WEST SUSSEX COUNTY COUNCIL CONSULTATION

TO:	Arun District Council FAO: Amber Willard
FROM:	WSCC - Highways Authority
DATE:	10 March 2022
LOCATION:	128 Limmer Lane, Bognor Regis, PO22 7LR
SUBJECT:	FP/5/22/HH Erection of part single/part two storey front, side and rear extensions, pool plant room and pool, installation of vehicular crossover and driveway, following the demolition of existing extensions, garage and timber shed.
DATE OF SITE VISIT:	n/a
RECOMMENDATION:	Advice
S106 CONTRIBUTION TOTAL:	n/a

DRAWING TITLE
PROPOSED SITE LAYOUT PLAN

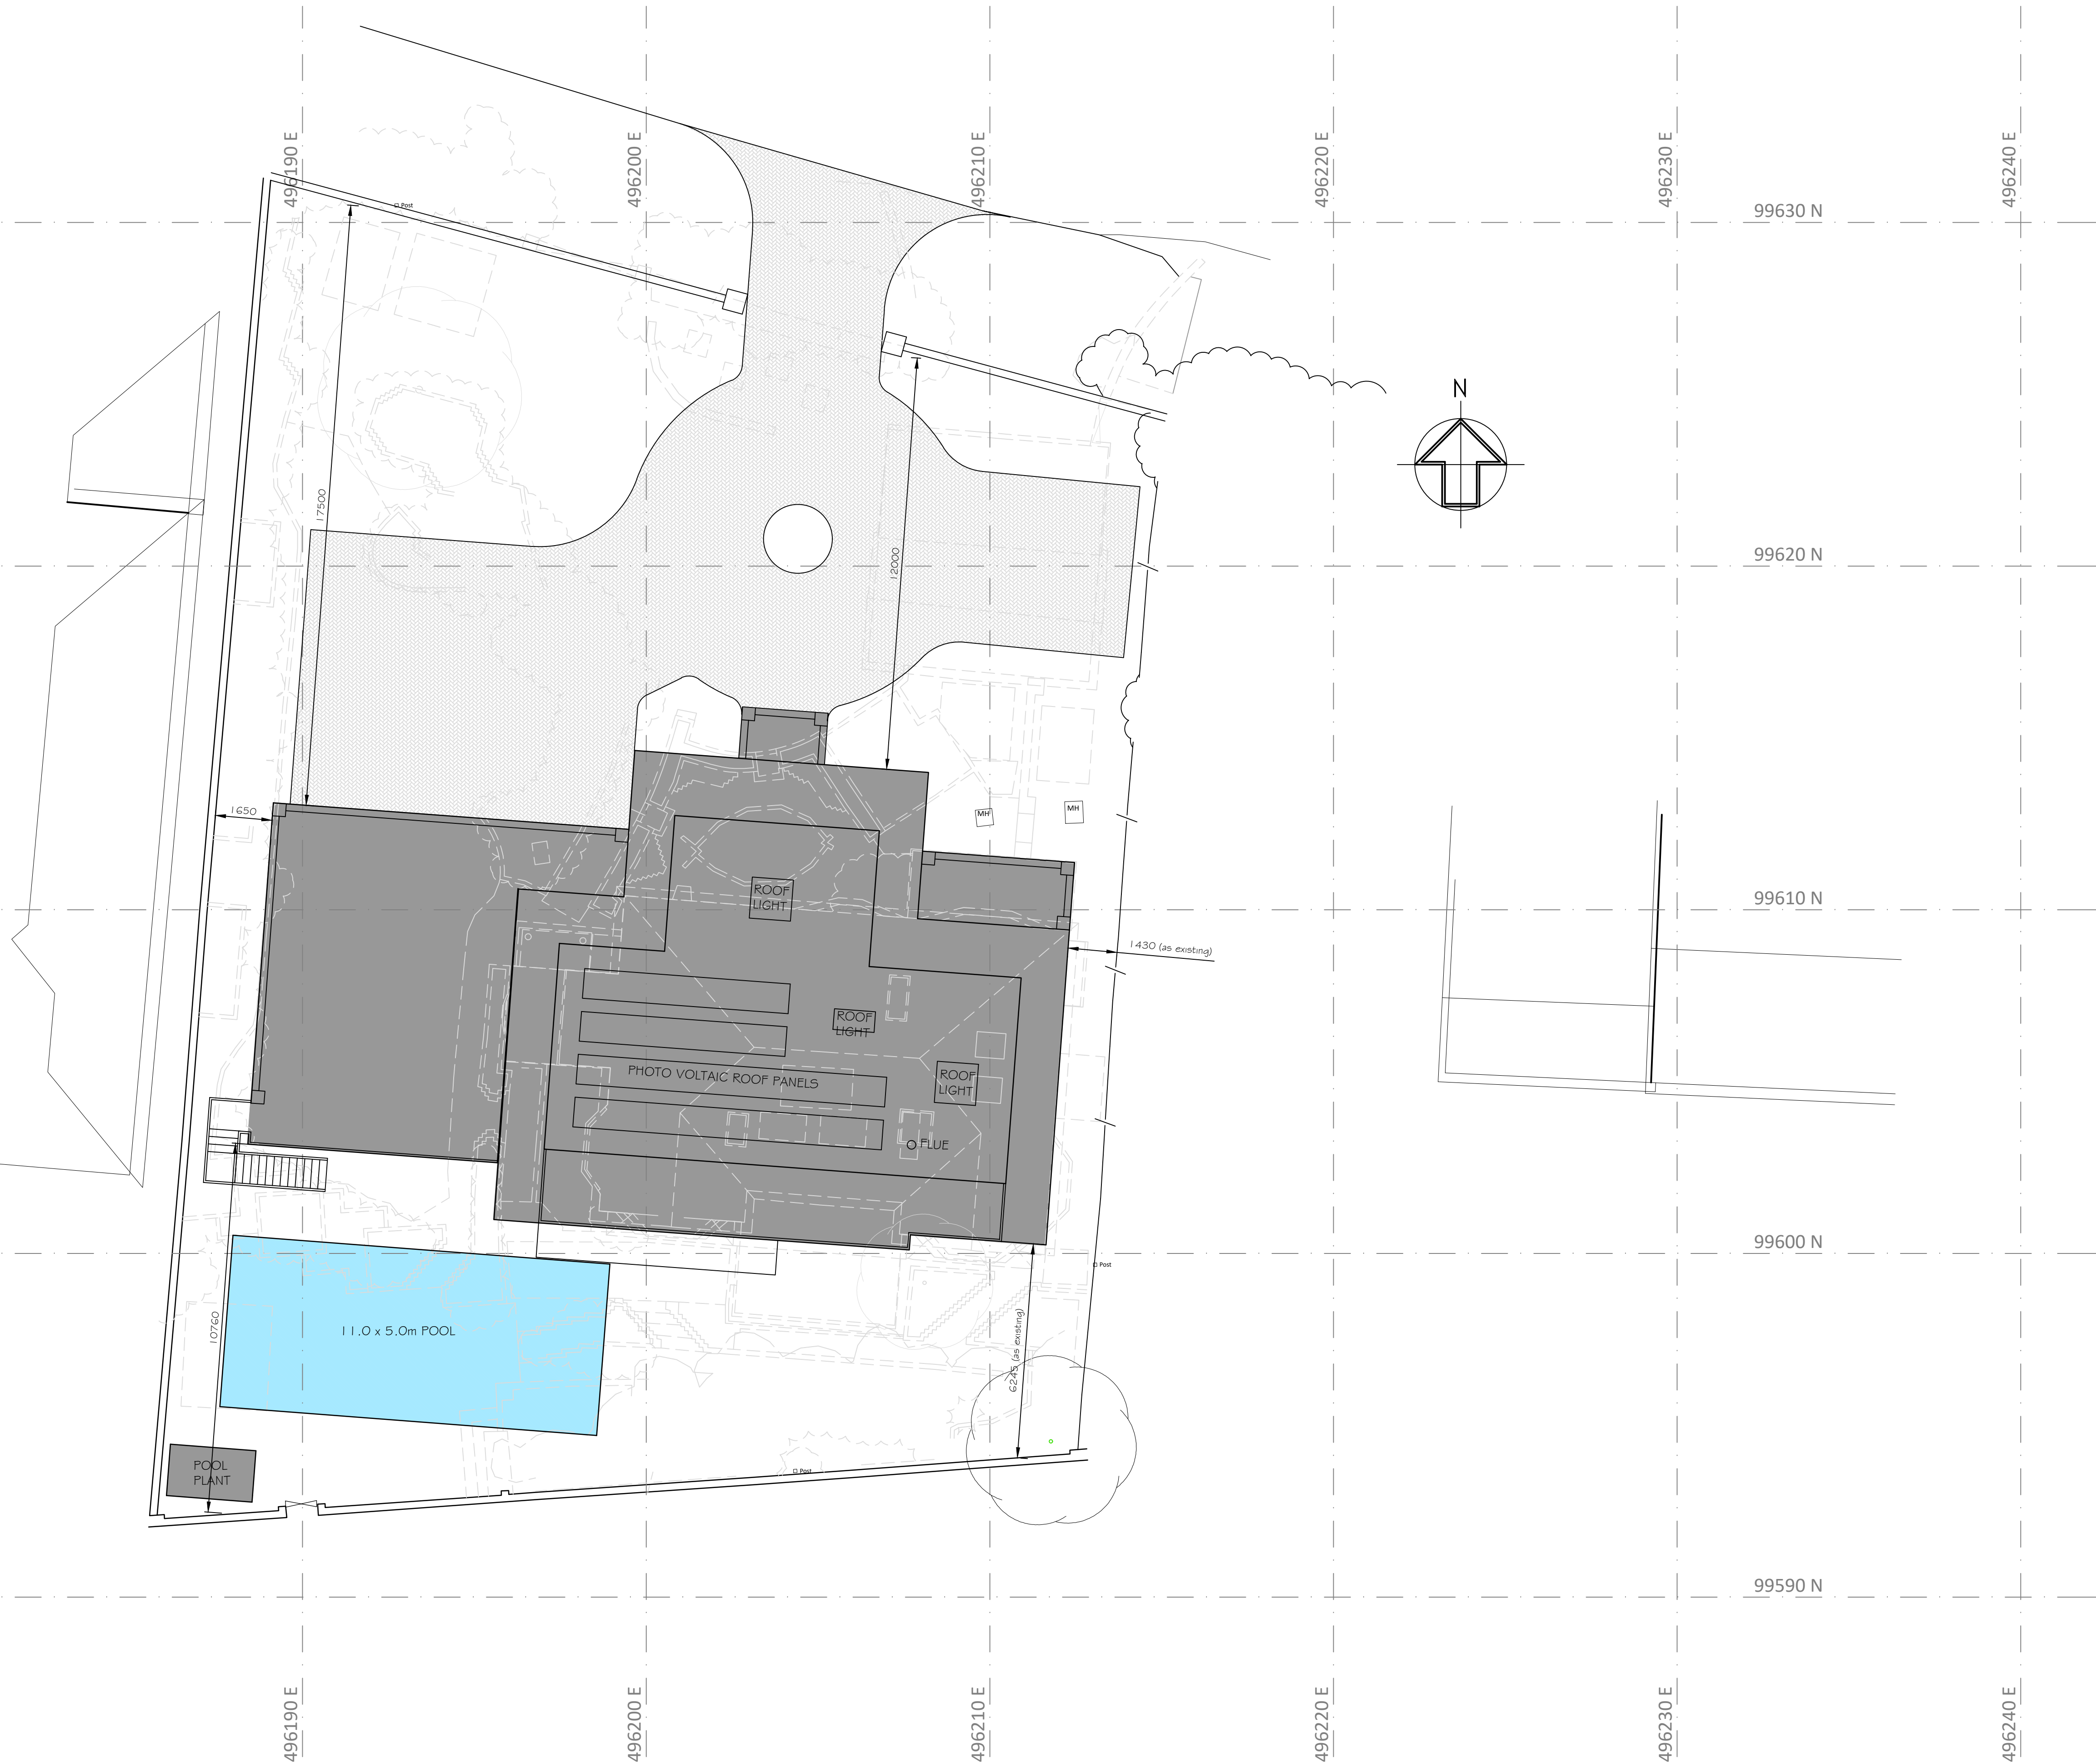
While the existing garage is to be lost a replacement garage is proposed. The site also benefits from an extensive hardstanding area which is considered suitable to meet the parking needs of the extended dwelling.

Limmer Lane is a private road and therefore the access works, formation and closure, are not strictly within the remit of the Local Highways Authority to comment upon. It is noted that Limmer Lane is however a Public Right of Way (Bridleway 3043_1), who may wish to make comment in due course from a public right of way perspective. The applicant would be advised to agree any approved access works with the proprietor of Limmer Lane prior to commencement.
